**APPLICATION BY ENERGIE BADEN-WÜRTTEMBERG AG (EnBW) AND ‘bp’ FOR  
AN ORDER GRANTING DEVELOPMENT CONSENT FOR THE MORGAN  
GENERATION OFFSHORE WINDFARM PROJECT**

**APPLICATION REF: EN010136**

**WRITTEN REPRESENTATION OF THE HISTORIC BUILDINGS AND MONUMENTS  
COMMISSION FOR ENGLAND (HISTORIC ENGLAND)**

Figure 1.5: Geophysical Anomalies with high archaeological potential within the Morgan Generation Assets marine archaeology study area.

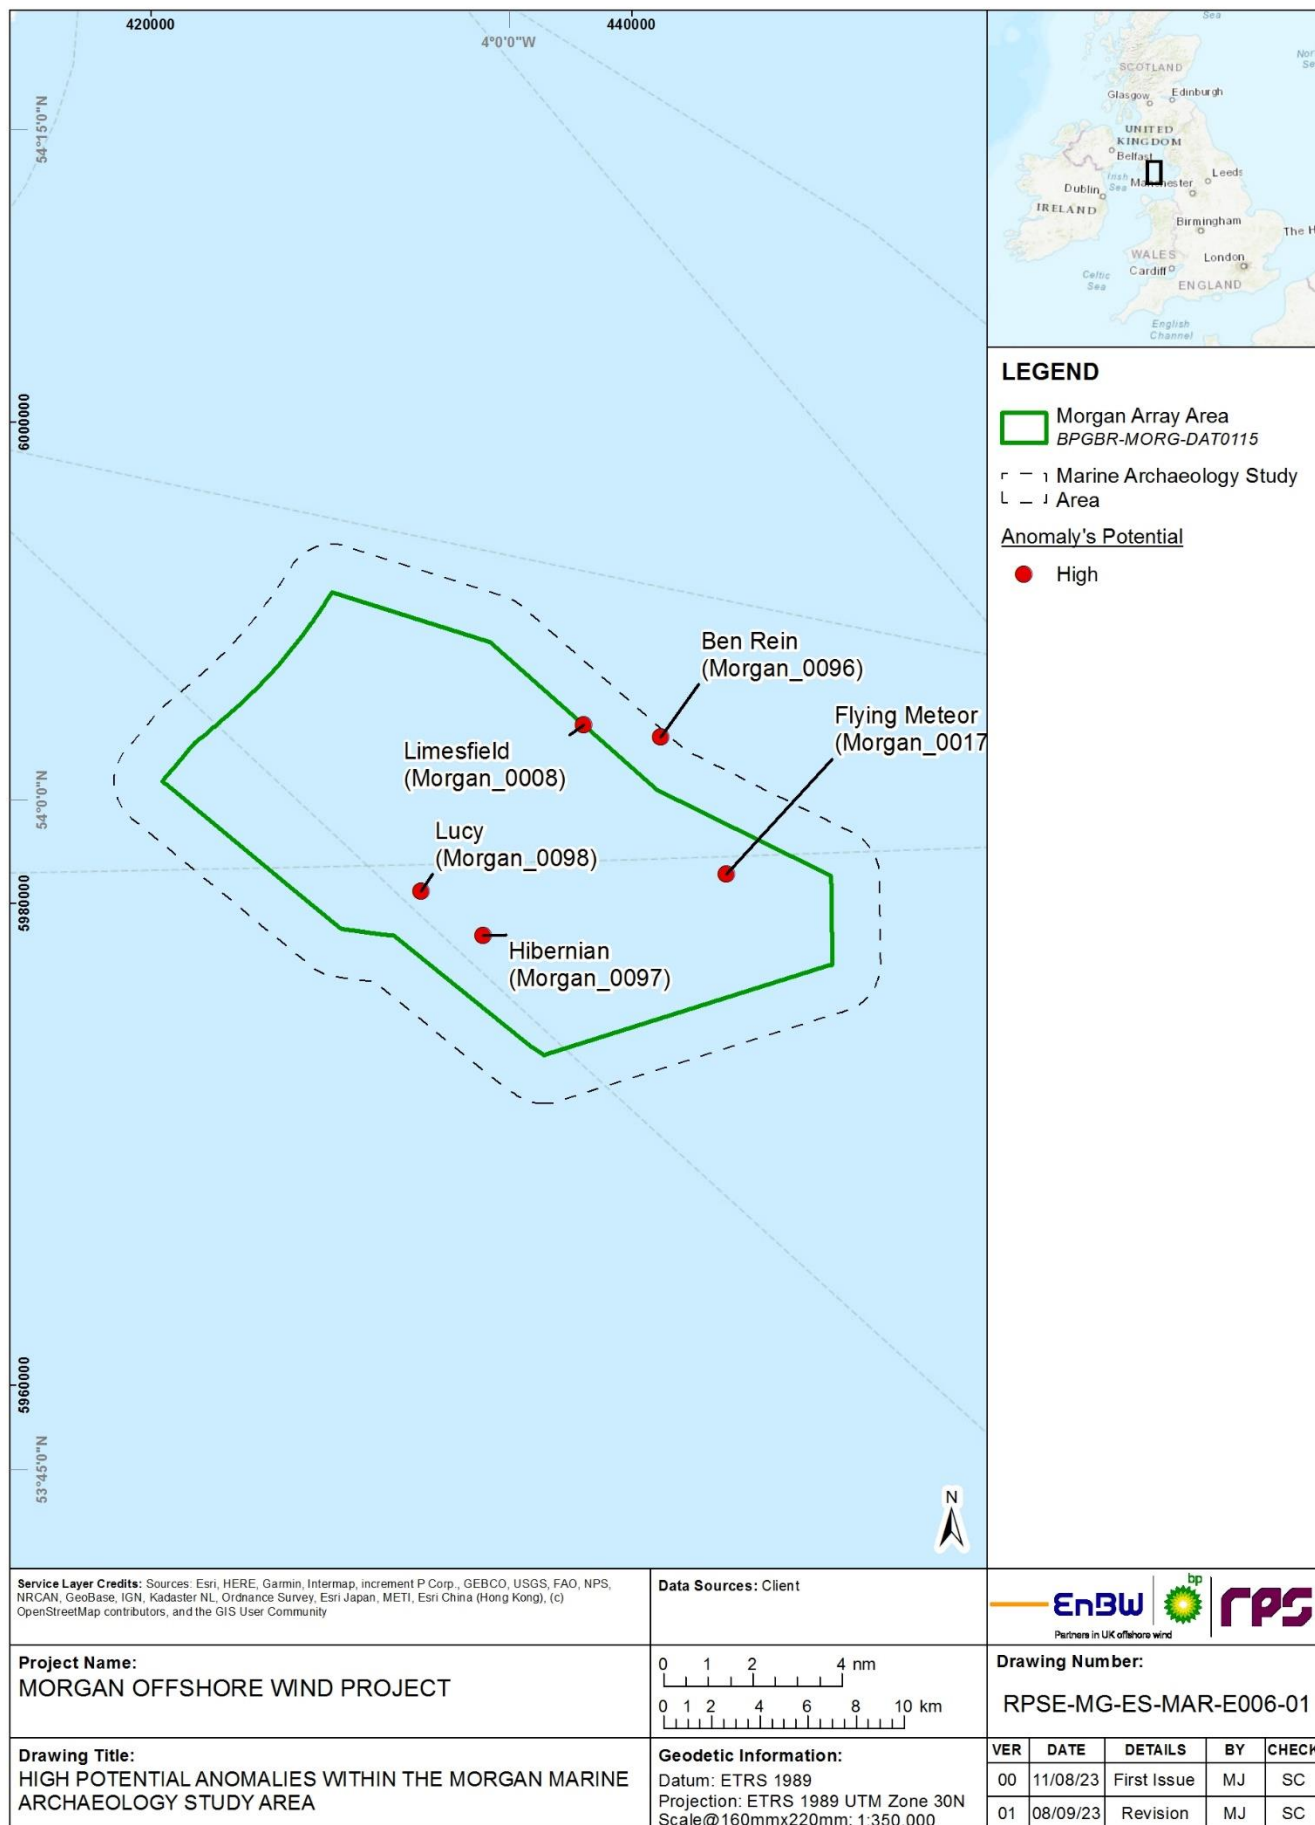
- 5.4 Section 1.5.8 states that a total of 51 anomalies of potential archaeological interest were identified within the wider Morgan marine archaeology study area (Figure 1.5):

- 5.6 The identified “high potential” anomalies all appear to correspond with live UKHO records. It was noticeable from the information presented that two wrecks were the result of an attack by the same U-boat (UB 57) on 7<sup>th</sup> February 1918 (as noted in paragraph 1.6.2.1) and therefore there is a collective significance. However, all these wrecks should be effectively avoided by the use of AEZs which must be sufficient to not only enclose the readily identifiable wreck structure, but any associated debris fields (e.g. anomalies Morgan\_0097 and Morgan\_0098). This is an important matter considering the proposed use of gravity base foundations which will require spatially extensive dredging to facilitate placement.

Figure 1.6: Proposed AEZs and TAEZs within the Morgan Array Area and marine archaeology study area.

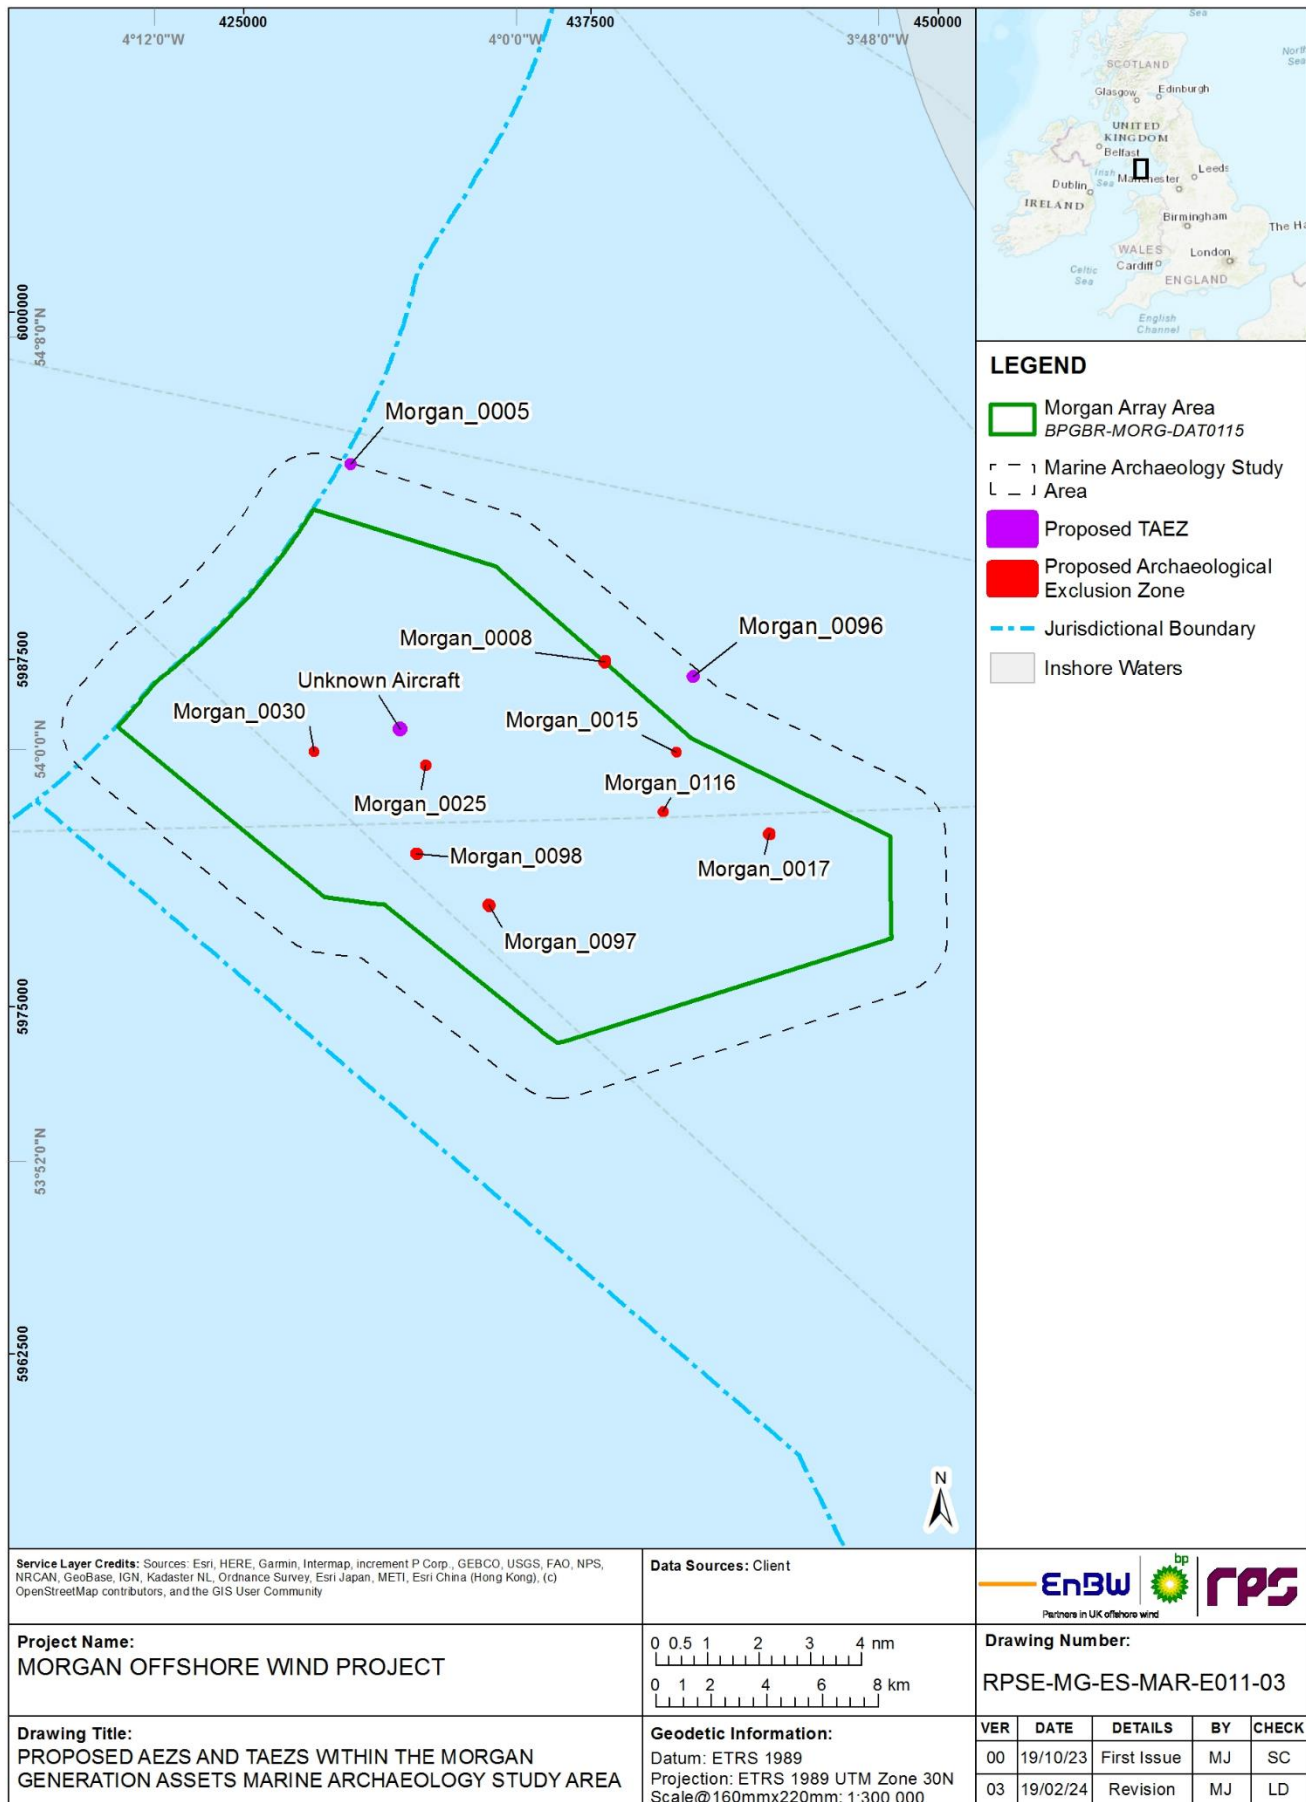
- 4.6 Sub-section 8.7.2 (Archaeological exclusion zones) we concur with the decision to place AEZs, either individually or in cluster configuration around the anomalies considered to be of either ‘high’ or ‘medium’ potential (paragraph 8.7.2.3). Also, the use of a Temporary AEZ (TAEZ) for the charted aircraft crash location and two sites in the array buffer zone, as illustrated in Figure 8.5.
